Your reference: SSD-71547218

Development Application

**State Significant Development – EIS & DA Exhibition – Waste or resource management facility
8 Styles Street Kurri Kurri NSW 2327, 1//DP1309128**

The RFS has reviewed the bush fire hazard assessment, undertaken in the bush fire report prepared by Cool Burn Pty Ltd (Version 1.1 and dated 12 February 2025) to demonstrate compliance of the proposed works with relevant provisions of Planning for Bush Fire Protection (PBP) 2019.

**Proposed Site Plan**  
 Scale: 1 : 500

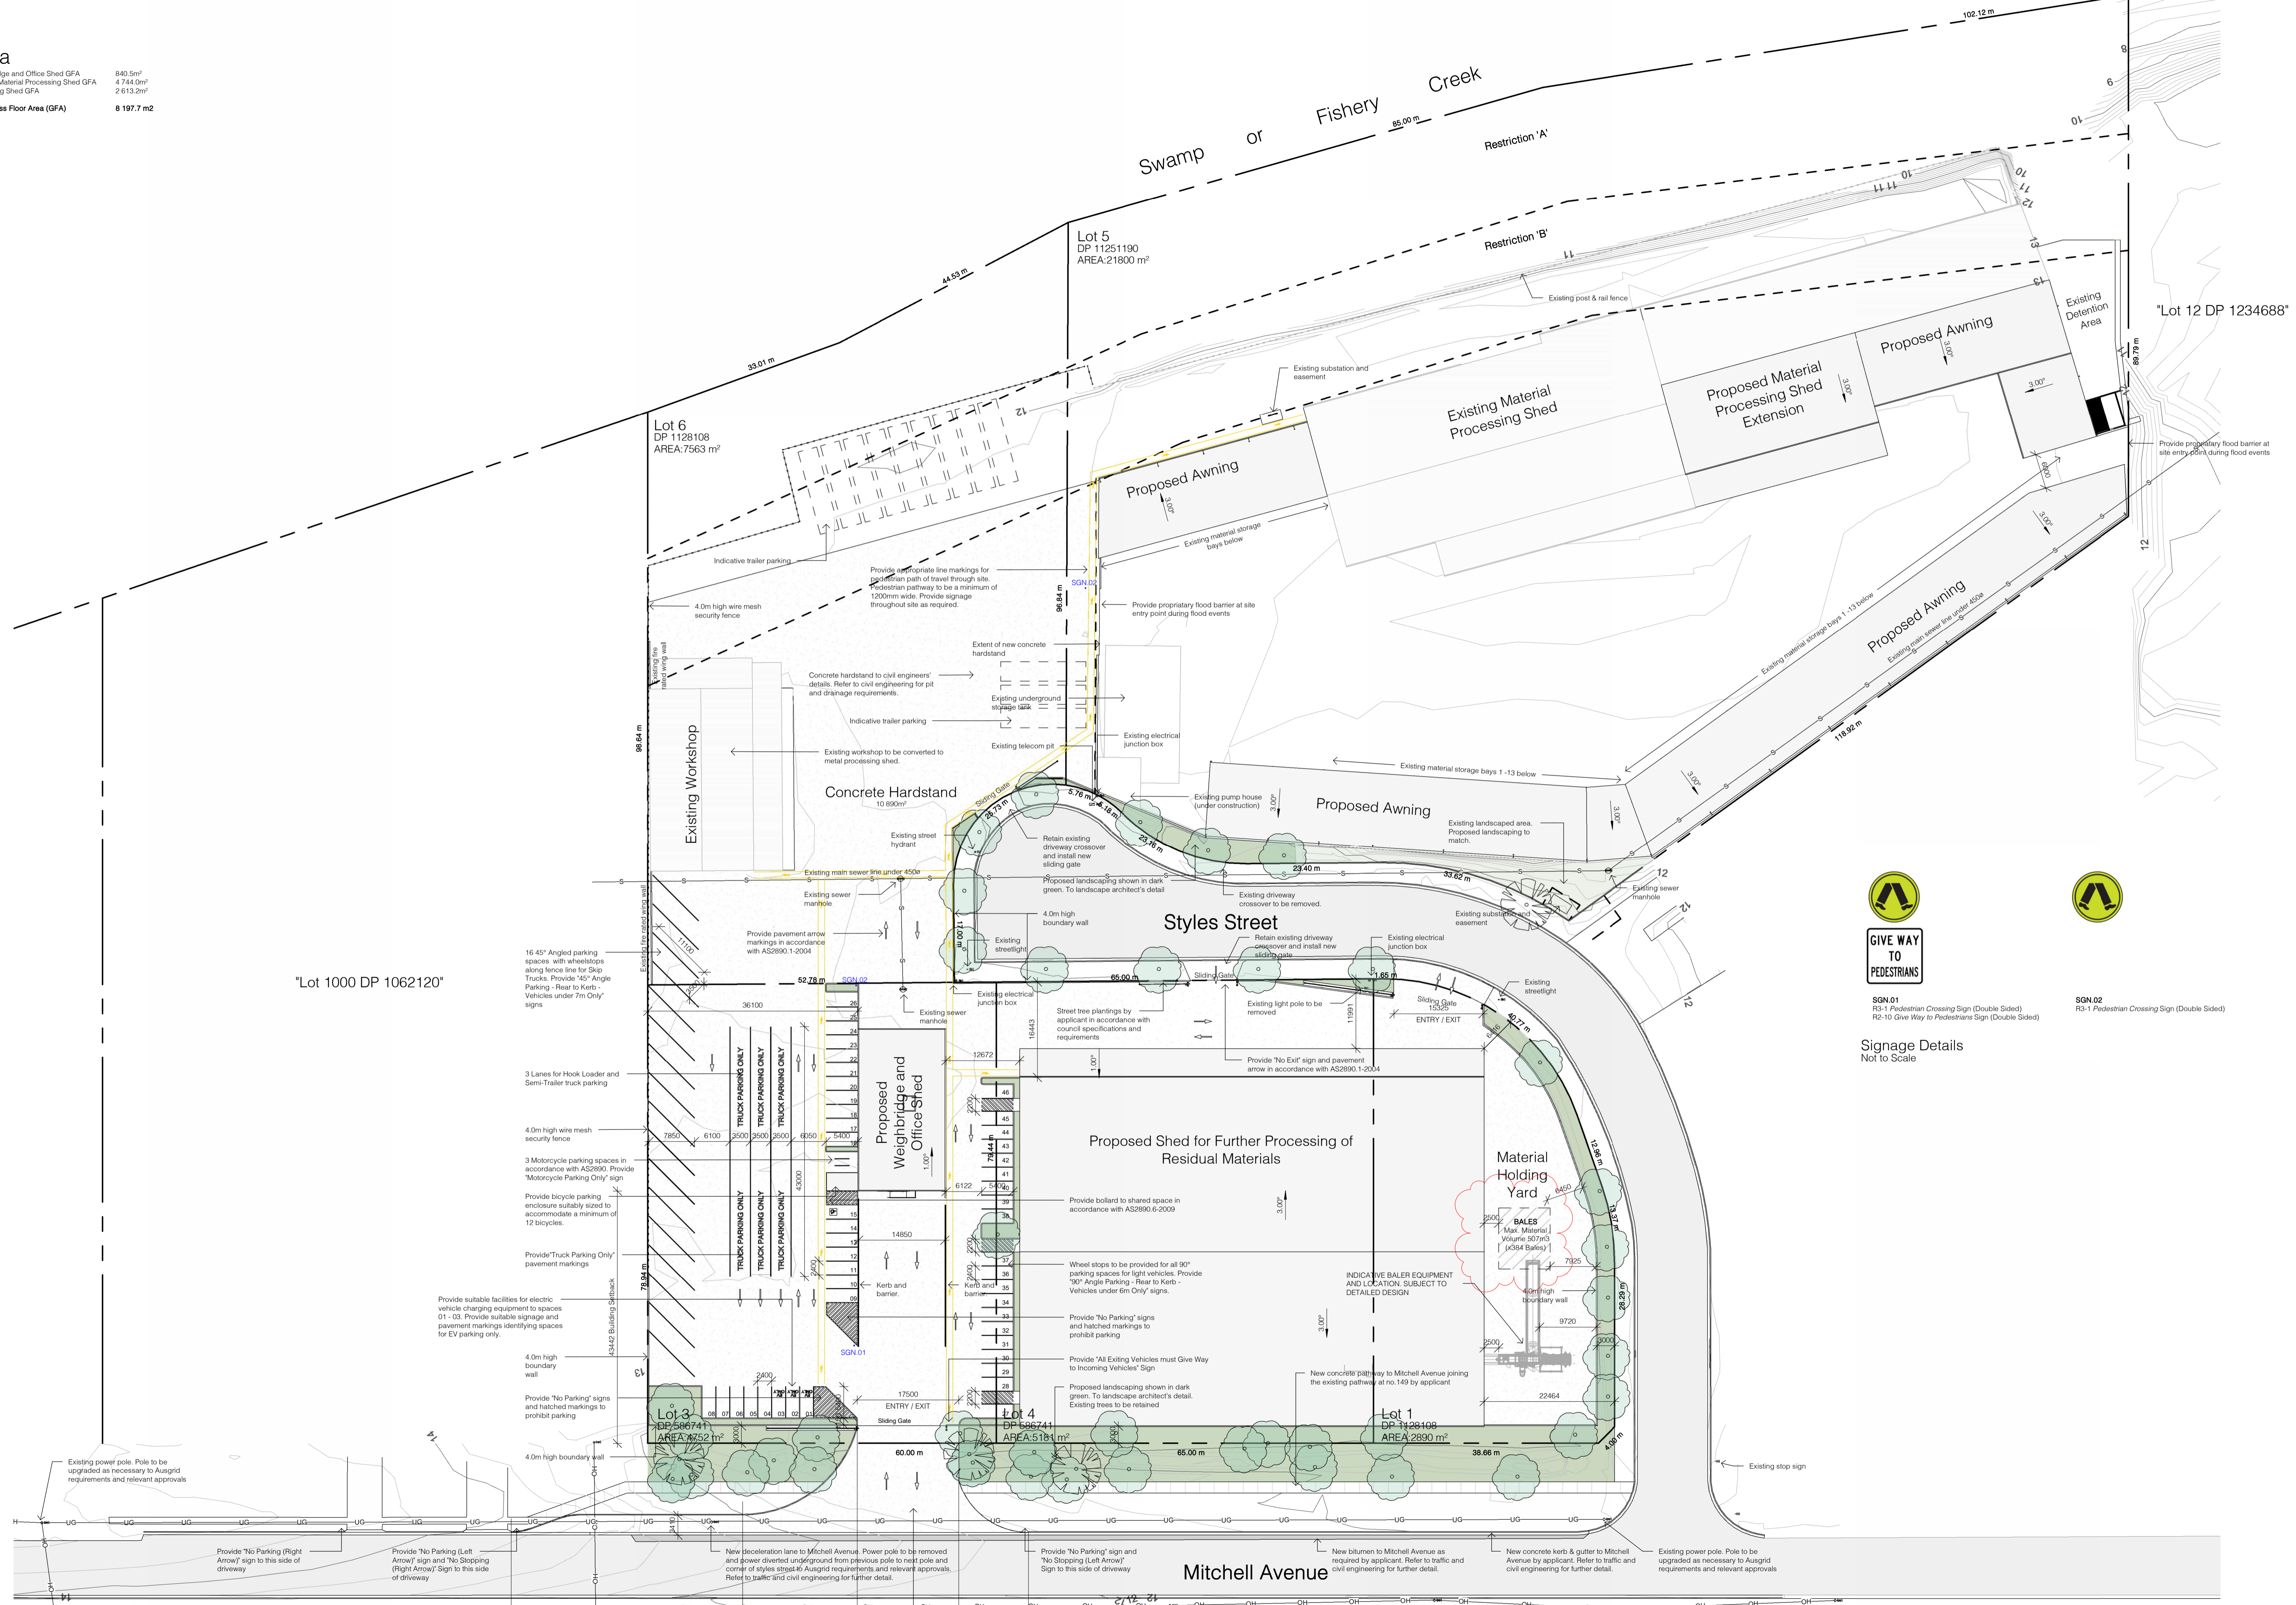
2. Prior to the commencement of building works and in perpetuity, a suitably worded instrument(s) pursuant to Section 88B of the *Conveyancing Act 1919*, must be within the subject site which creates an Asset Protection Zone (APZ) as shown as 'Restriction B' on proposed Site Plan prepared by Thomas and Associates Consulting Pty Ltd, (dated 09/10/2025, Project Ref: 230499, Dwg No: A103, Issue: G) and prohibit any construction within the proposed APZ (proposed use for fire fighting and drenching purposes). The name of authority empowered to release, vary or modify the instrument shall be the Cessnock City Council. The APZ must be managed as an inner protection area (IPA) in accordance with the requirements of Appendix 4 of *Planning for Bush Fire Protection 2019*.

Weighbridge Shed - Ground Floor Plan  
Scale: 1 : 100

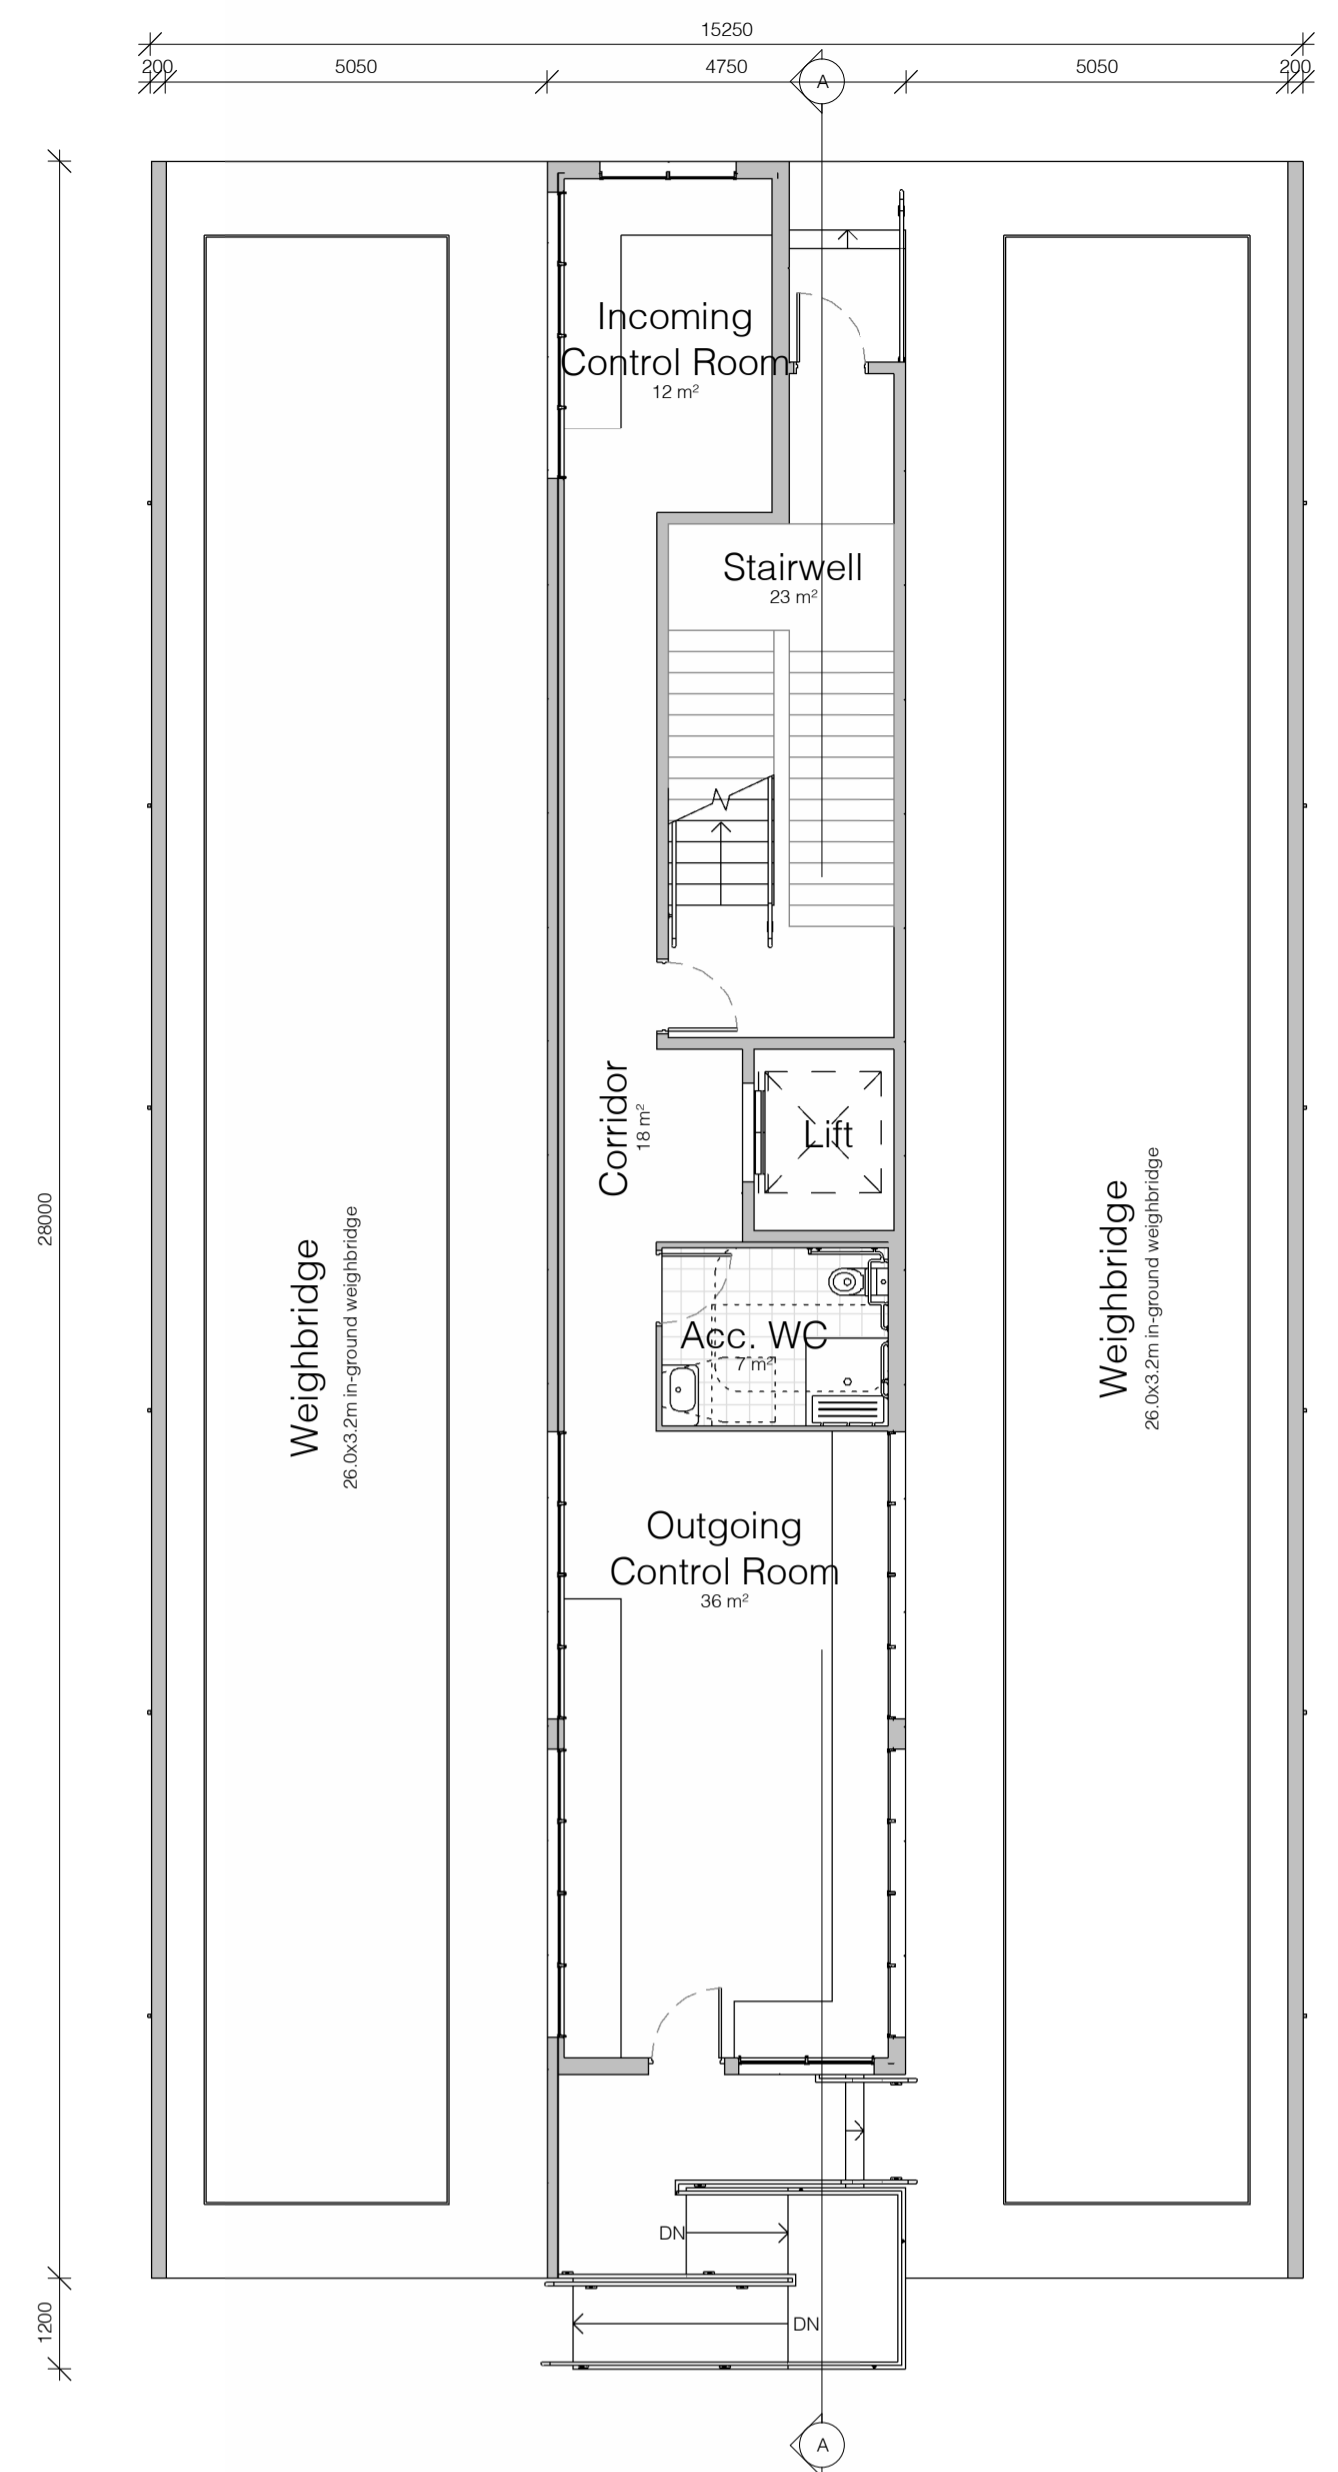
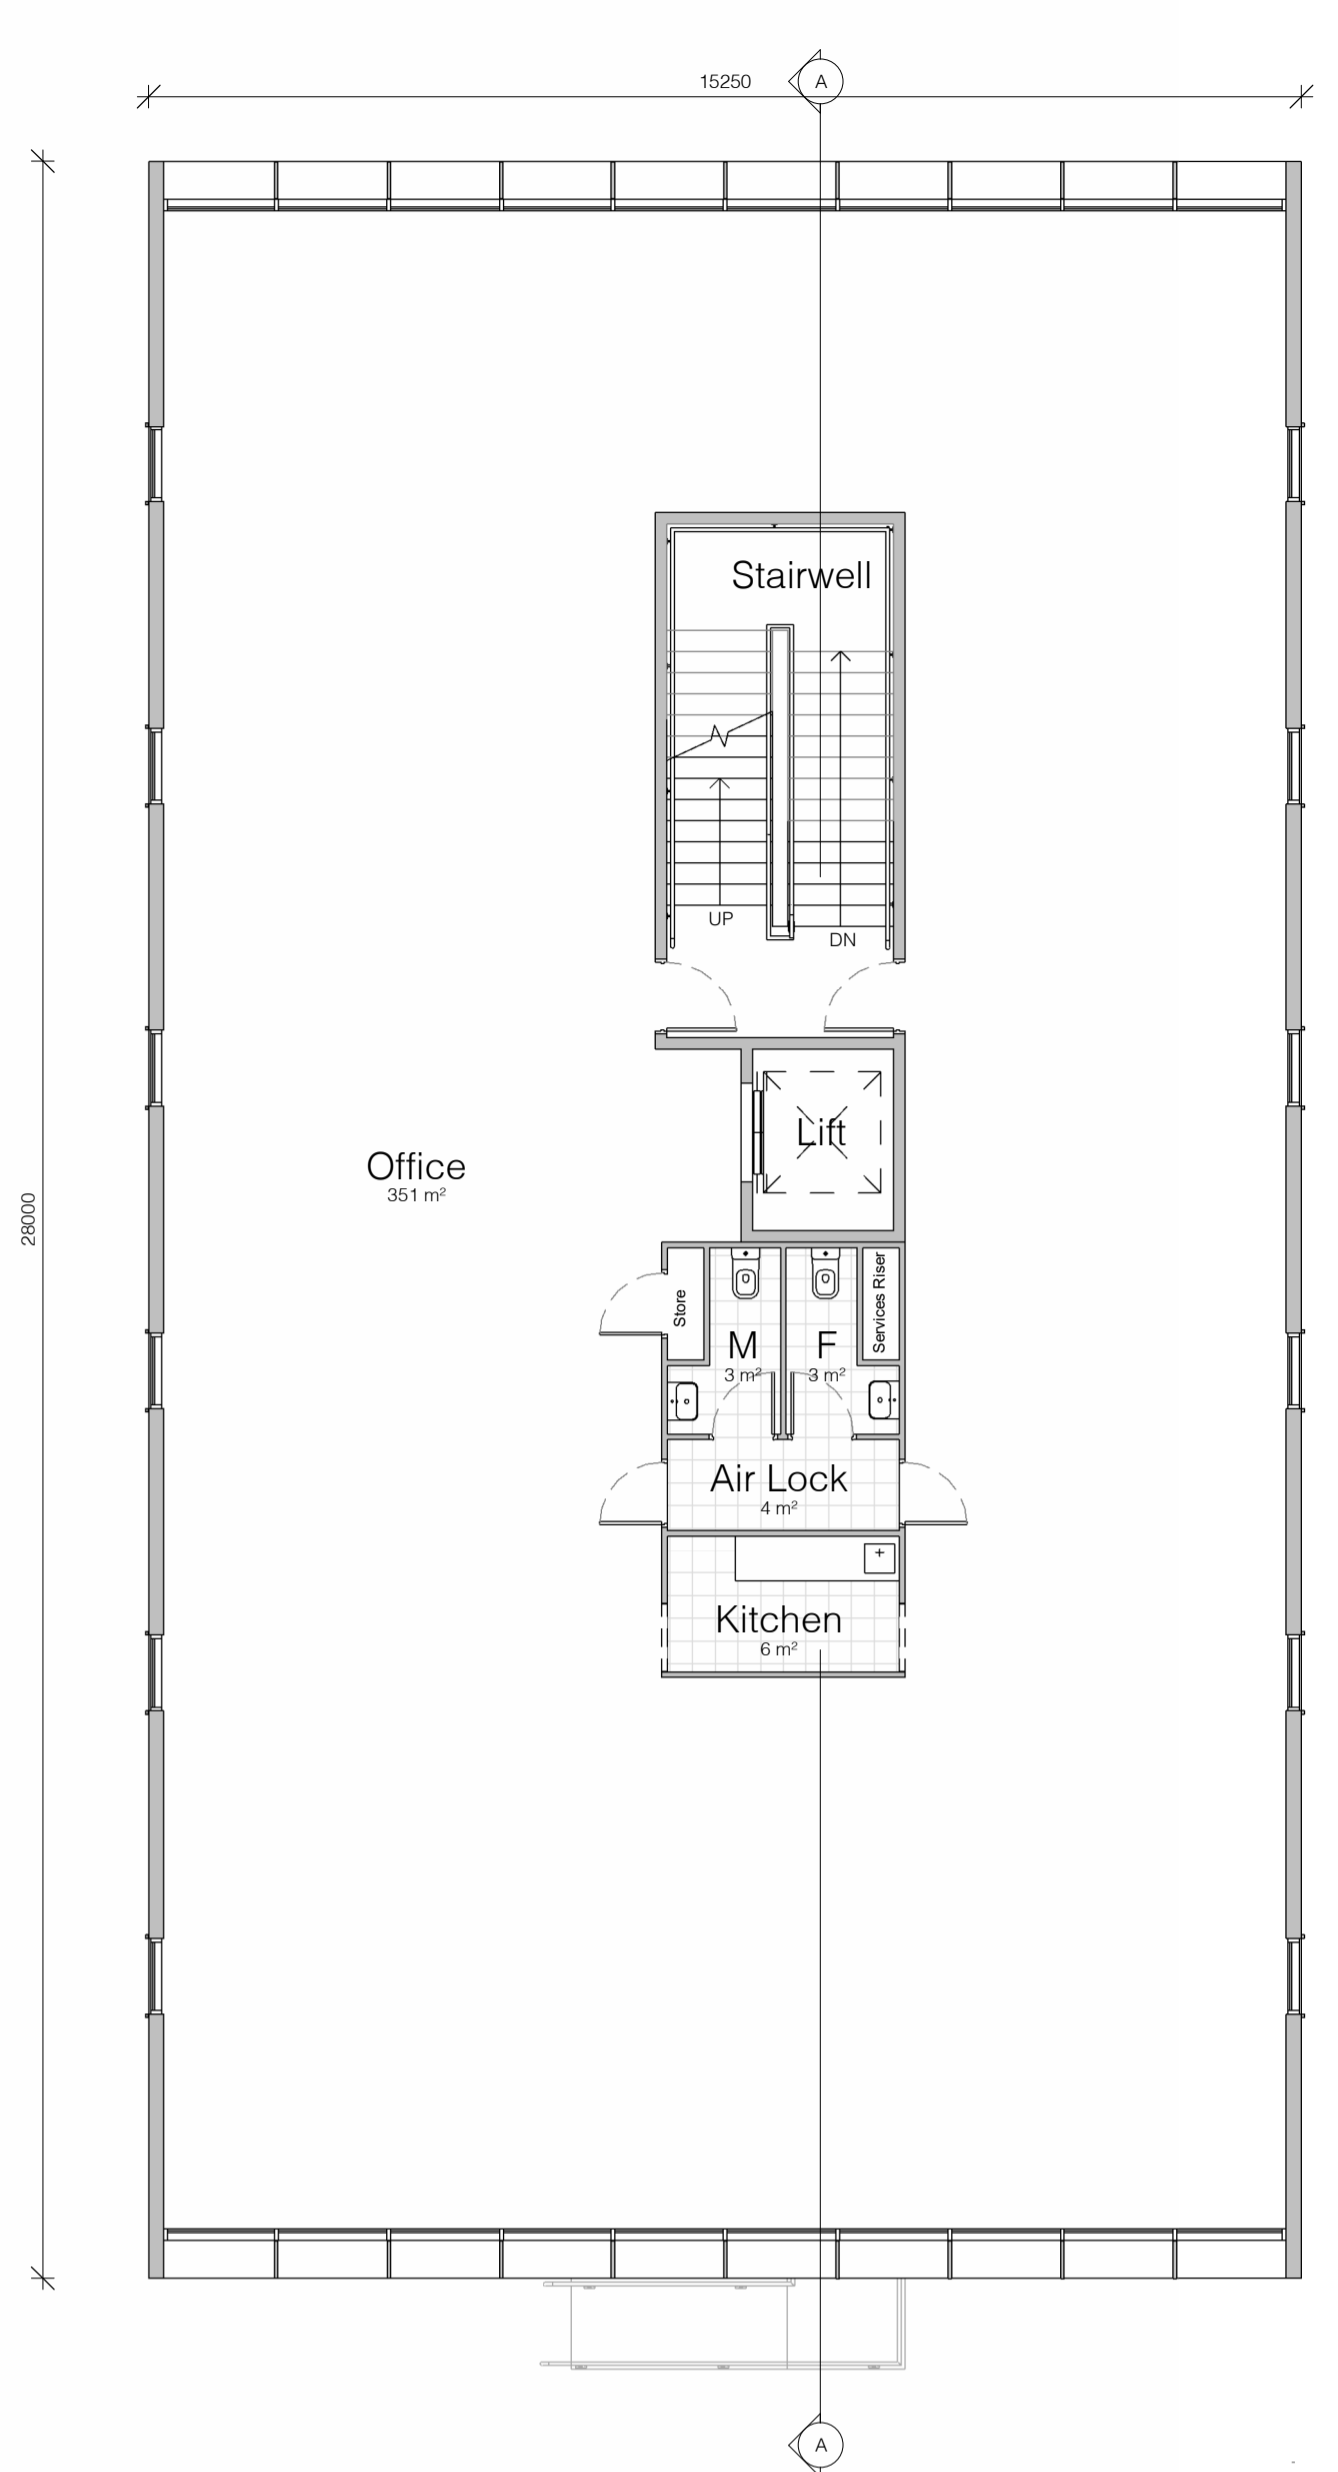
5. The proposed offices located above the weighbridge, must be upgraded to improve ember protection by enclosing all openings (excluding roof tile spaces) or covering openings with a non-corrosive metal screen mesh with a maximum aperture of 2mm. Where applicable, this includes any sub floor areas, openable windows, vents, weepholes and eaves. External doors are to be fitted with draft excluders.
